Our Ref: EN070005

Date: 13 January 2020

**Application by Esso Petroleum Company, Limited for an Order Granting
Development Consent for the Southampton to London Pipeline Project**

**Request to Make Changes to the Original Application and Examining
Authority's Request for Additional Information**

Drawing title
**LAND PLAN
SHEET 37
REGULATION 5(2)(i)**

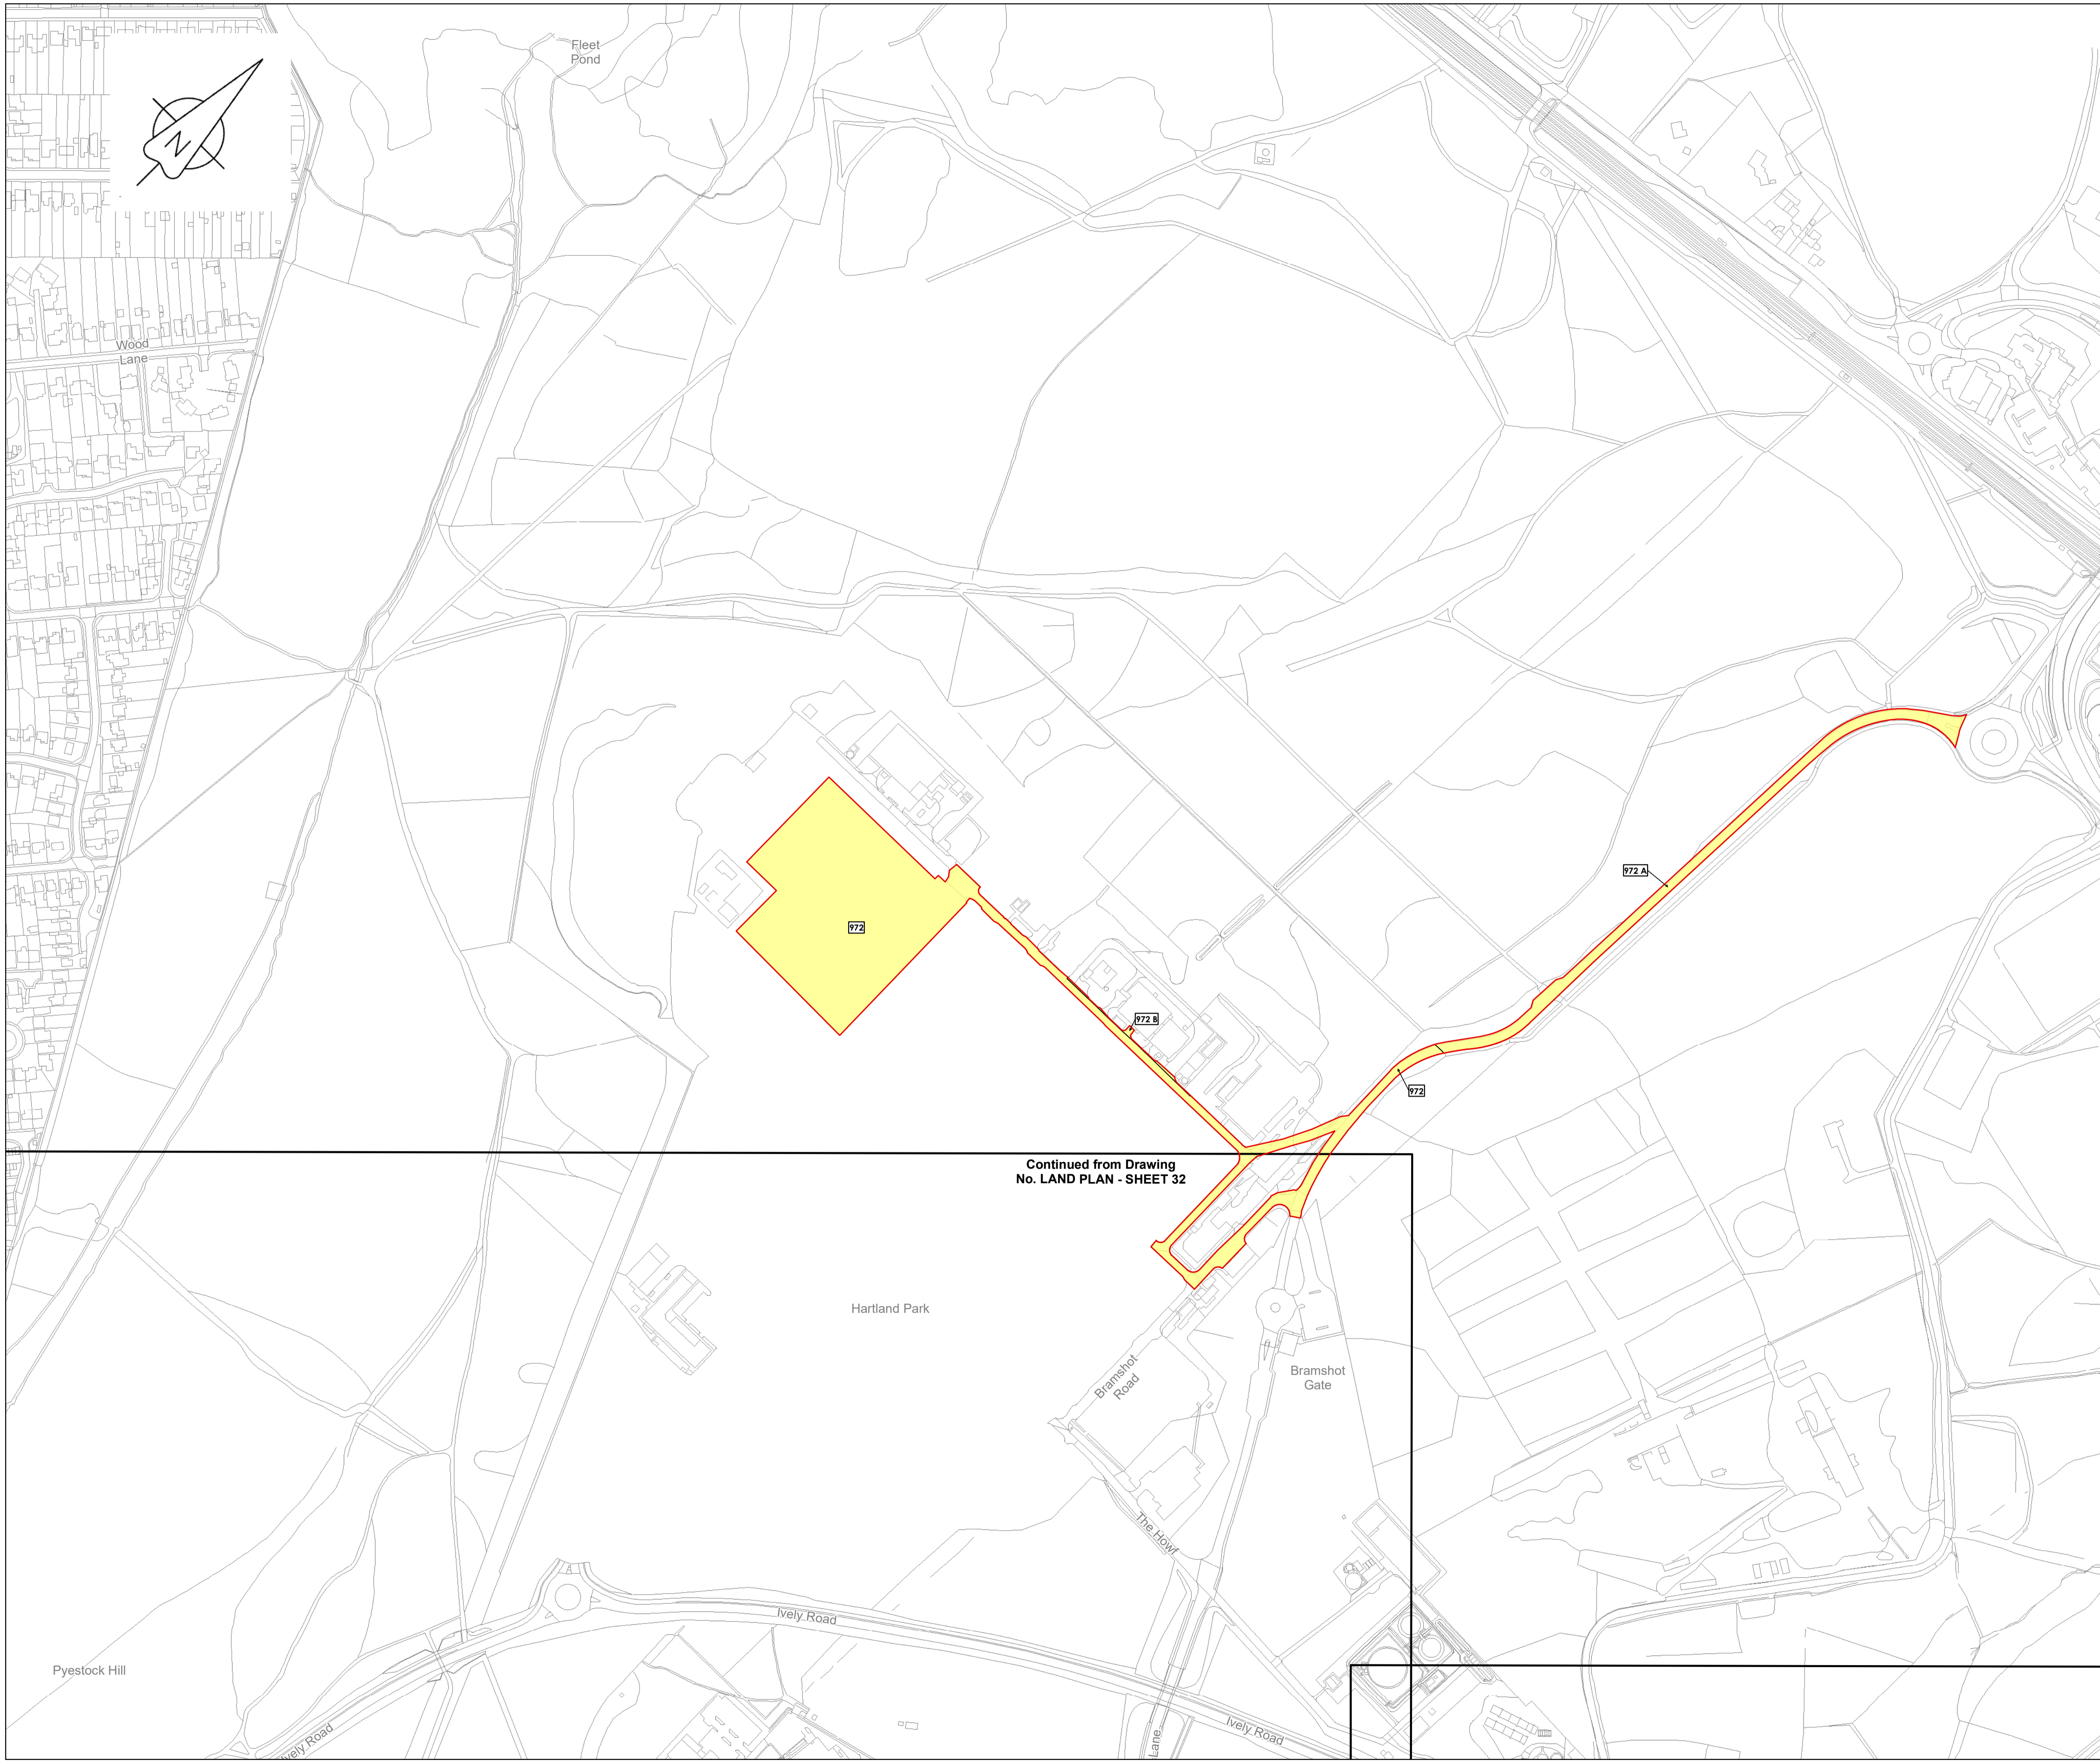
- b) Work No 7A, Deepcut, sheet 37 on the Land Plan [AS-043]
- c) Work No 6B, A31/A32 Junction, sheet 59 on the Land Plans [AS-044]

The ExA requests the Applicant provides additional information on the powers sought over the Order land as amended, i.e temporary possession powers or permanent possession.

Drawing title
LAND PLAN
SHEET 56
REGULATION 5(2)(i)

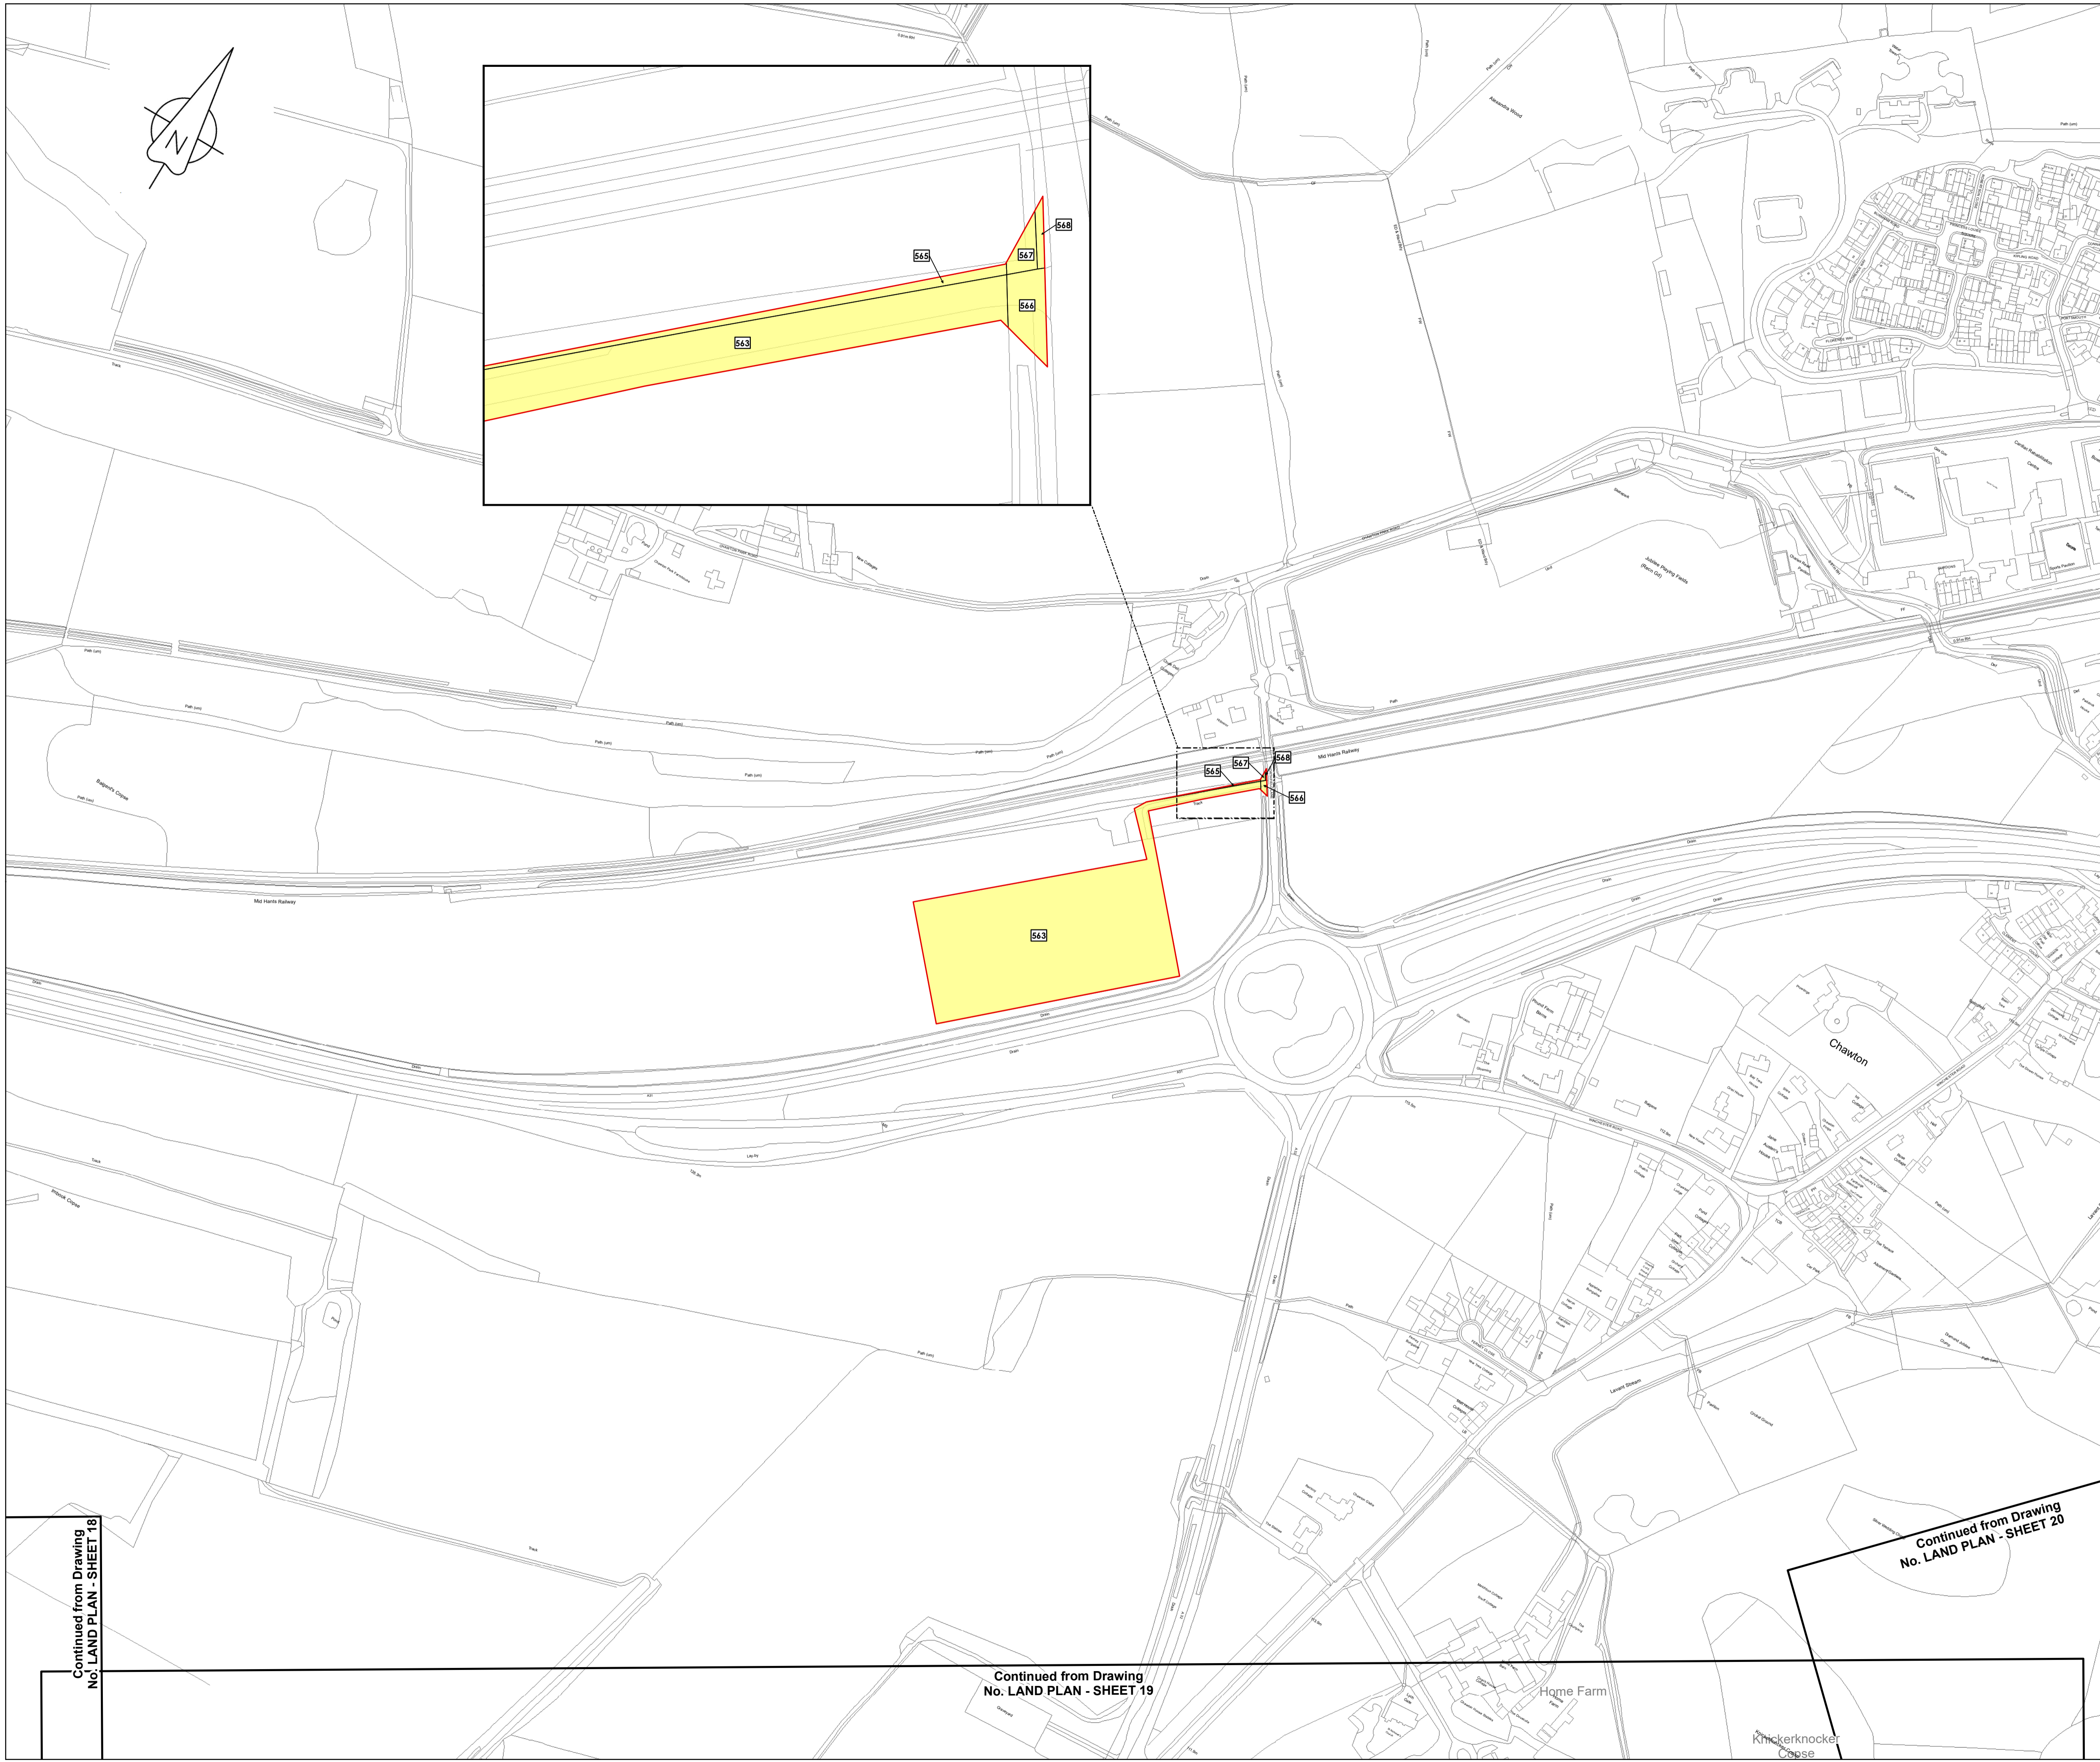
- a) Work No 6C Hartland Park Village, sheets 32 and 56 on the Land Plans [AS-043] and [AS-044]

The ExA notes that a section of the proposed access road, as well as an entirely new strip of roadway encompassing Bramshot Lane to the A327 Roundabout is now proposed to be included within the Order limits. The ExA requests the Applicant confirm this understanding of the Change Request [REP3-022] is correct and that it is to be included within the Order land.

The ExA requests that the Applicant provides additional information on the powers sought over the Order land as amended, i.e temporary possession powers or permanent possession.
